**City of Portland, Maine - Building or Use Permit Application**  
 389 Congress Street, 04101 Tel: (207) 874-8703, Fax: (207) 874-8716

Permit No: 03-0651	Issue Date: <b>PERMIT DENIED</b>	CBL: 428 B009001
-----------------------	-------------------------------------	---------------------

Past Use: single family	Proposed Use: single family - build 24' x 28' detached garage	Permit Fee: \$233.00	Cost of Work: \$30,000.00	CEO District: 2
		FIRE DEPT: <input type="checkbox"/> Approved <input type="checkbox"/> Denied	INSPECTION: Use Group: Type: <b>PERMIT DENIED</b>

FRONT ELEVATION
SCALE: 1/4" = 1'-0"

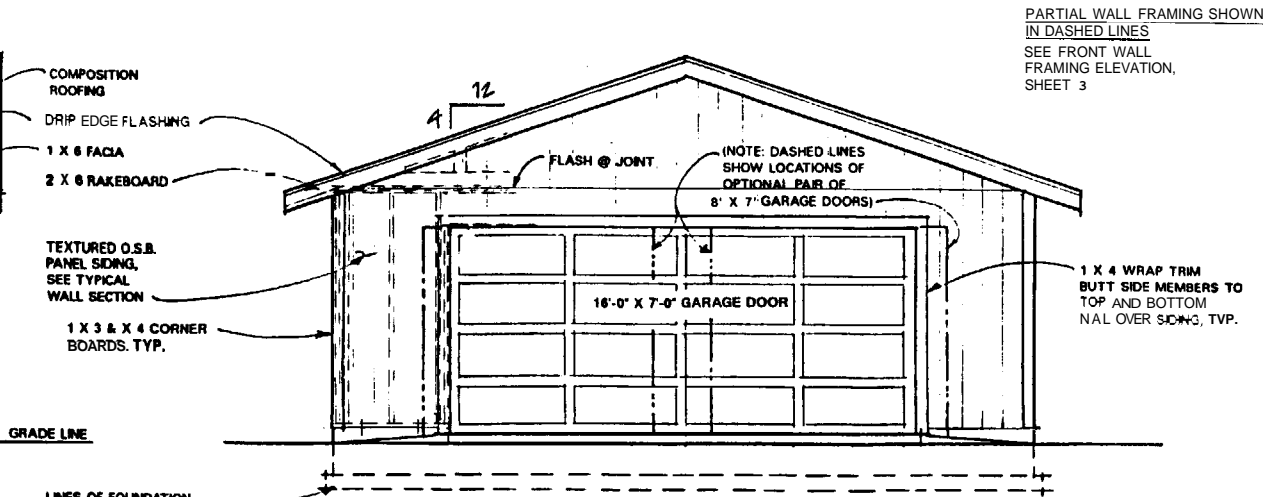
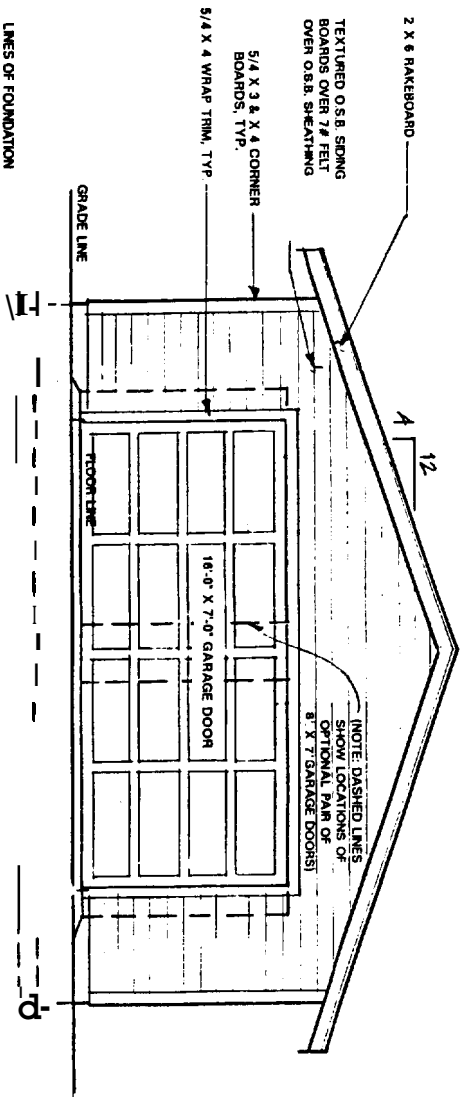
Dept: Zoning	Status: Denied	Reviewer: Tammy Munson	Approval Date:	Ok to Issue: <input type="checkbox"/>
Note: building is to tall				
Dept: Building	Status: Denied	Reviewer: Tammy Munson	Approval Date:	Ok to Issue: <input type="checkbox"/>
Note:

Comments: 6/13/03-tmm: spoke w/owner - building is over the 18' req height in that zone - permit denied Mike met w/owner and brother and went over req./
--
